# CITY OF ALBUQUERQUE

November 23, 2016

RE: **Aspen Ranch Apts. Phase 2, Bldgs. 31, 32, 33**  
**9677 Eagle Ranch Rd NW**  
**Requested for Temporary C. O. – Not Accepted**  
**Engineers Stamp Date 11/22/11 (B13D002B)**  
**Certification dated: 11-22-16**

DATE	10/10/2011
REVISED DATE	
SHEET	C1.1

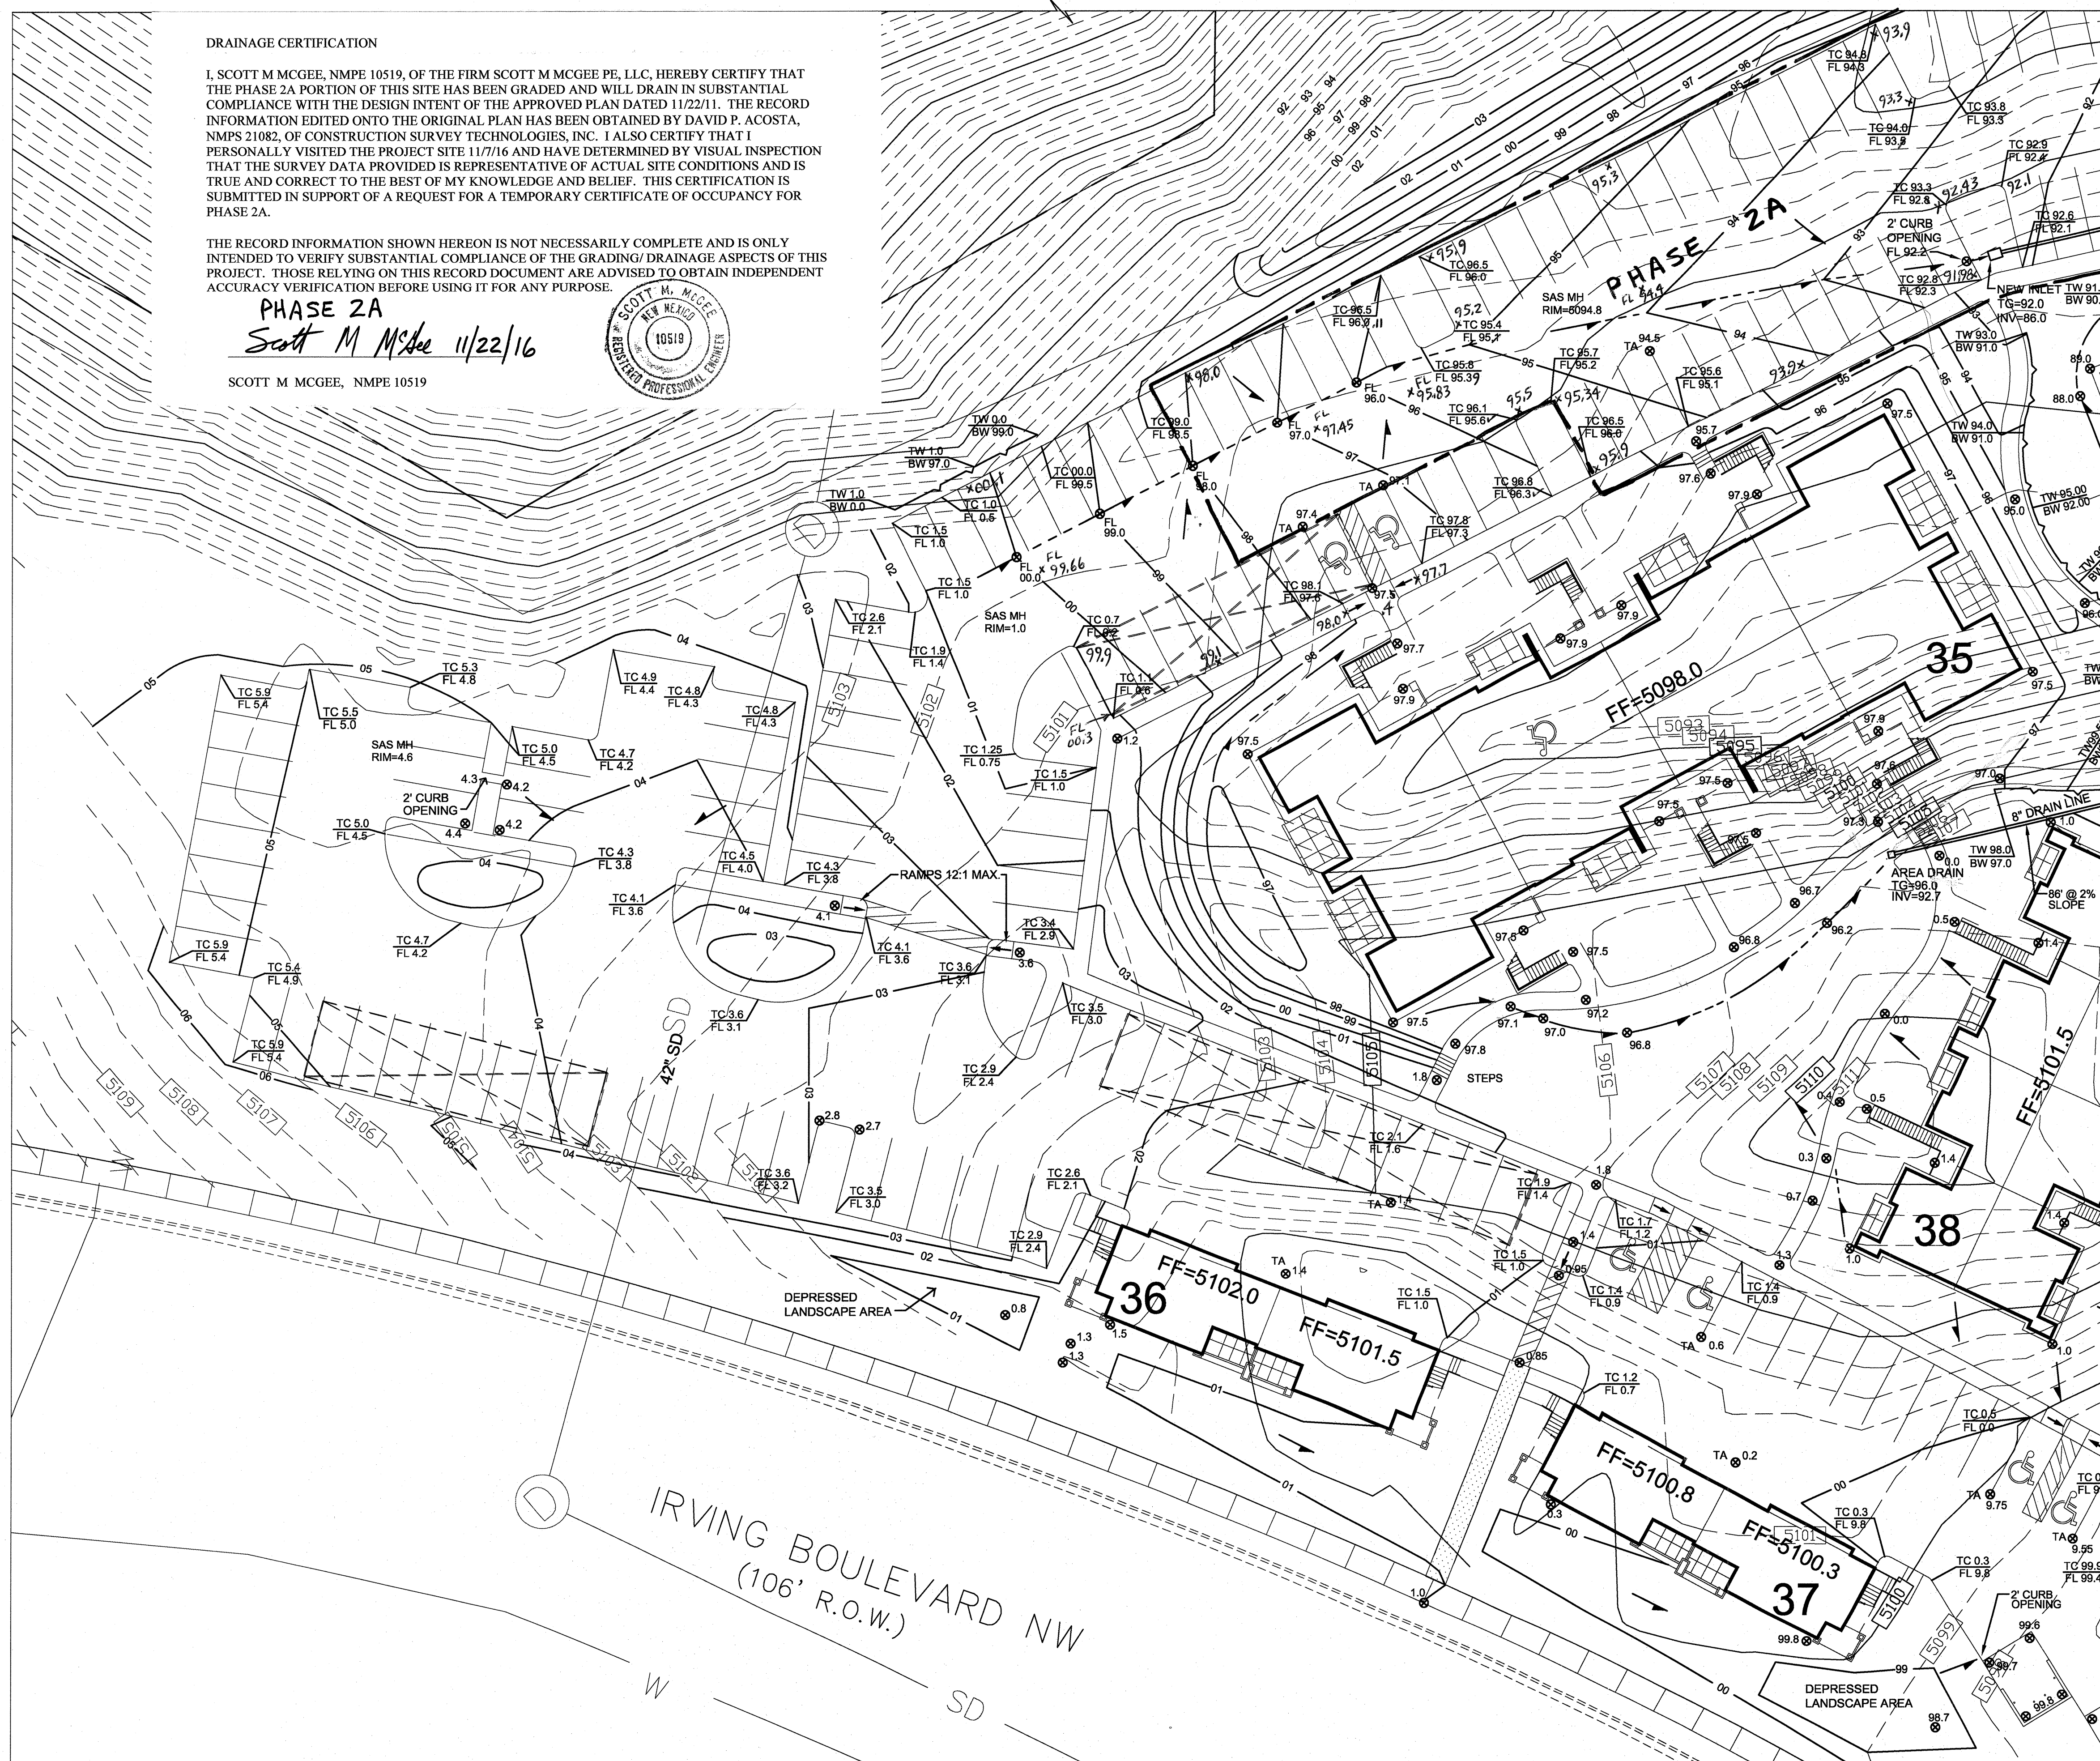
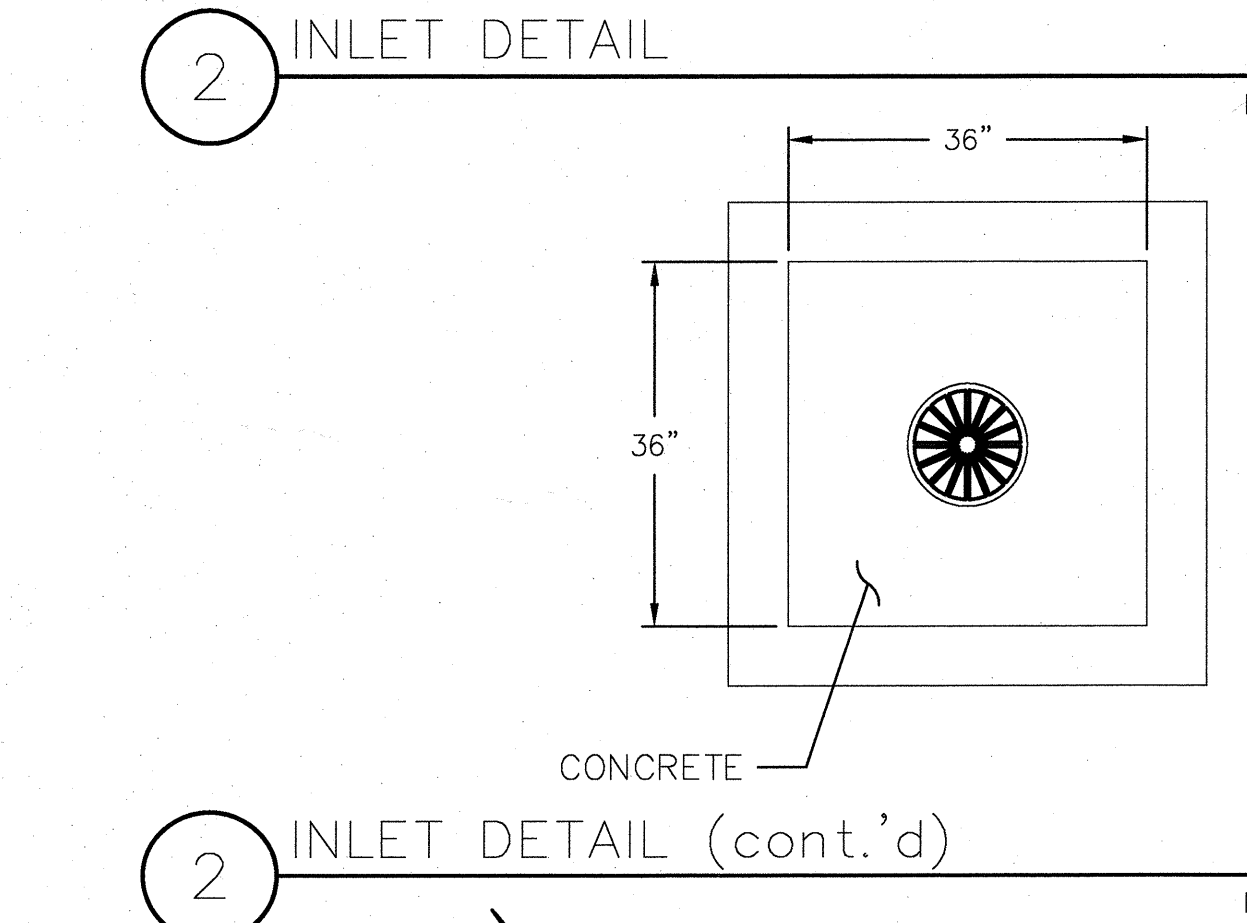
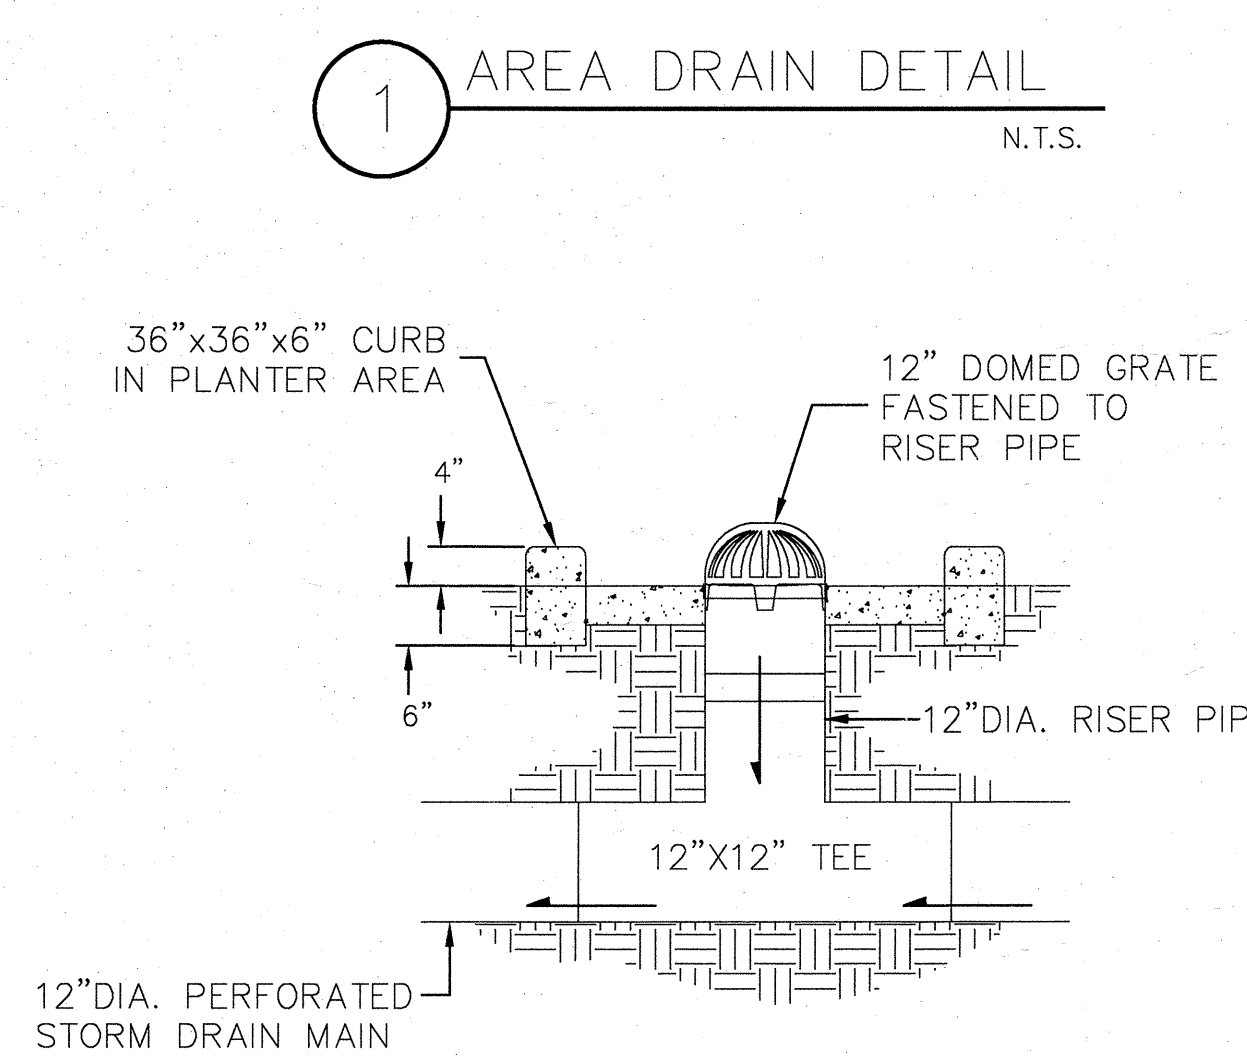
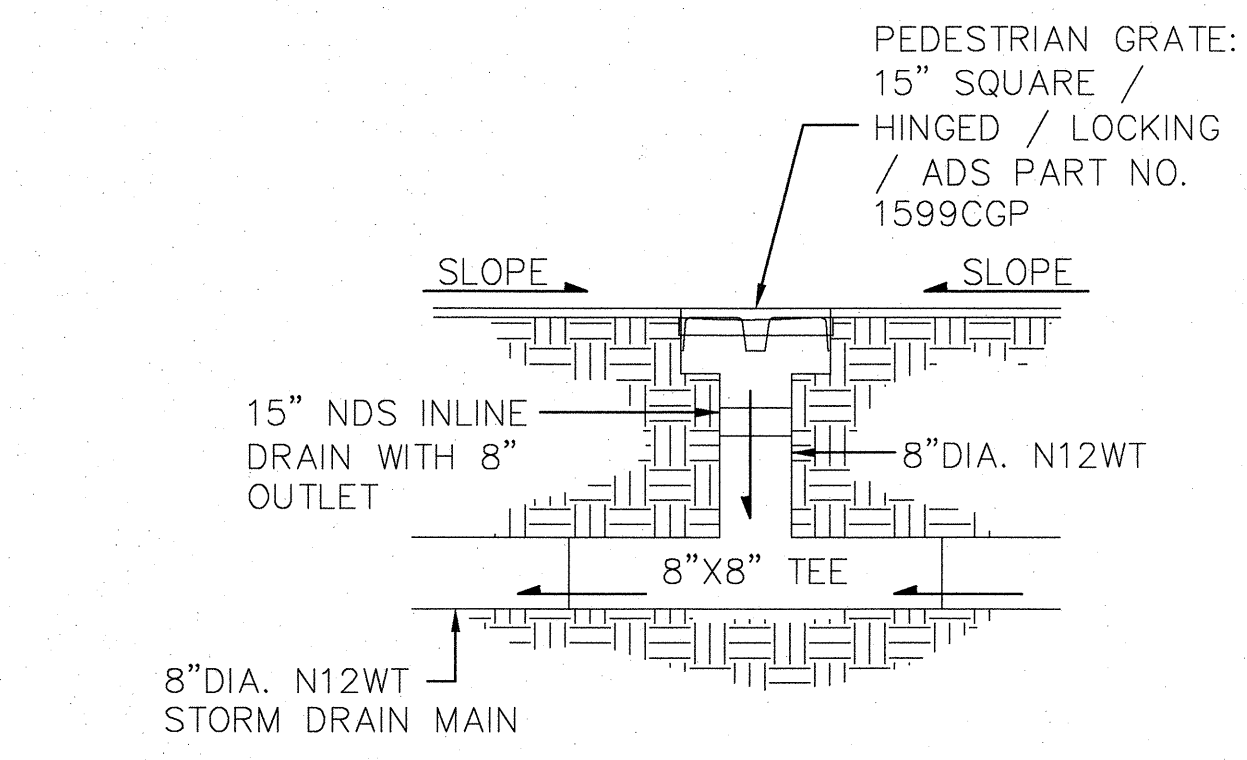
- The drain pipes underneath the sidewalks are missing in front of building 31.
- There are A/C units north of building 31 that interfere with the flows. Recommend addressing this issue otherwise the water will drain on to sidewalk.
- A construction fence is blocking the parking area partially in front of 34 and all of 35.
- There is a strip of concrete curbing in a parking space that is not as-built on the drawing in between buildings 33 and 34. It is blocking the flow and a mound of dirt has built up behind it.
- There is a sidewalk culvert in front of building 34 that is not as-built on the drawings.
- The curb cut in between building 34 and 35 is only 1'. It is supposed to be 2'.
- There is an additional landscaping area in the parking lot in front of building 35. It is not clear of design intent. It is not as-built on the drawings.
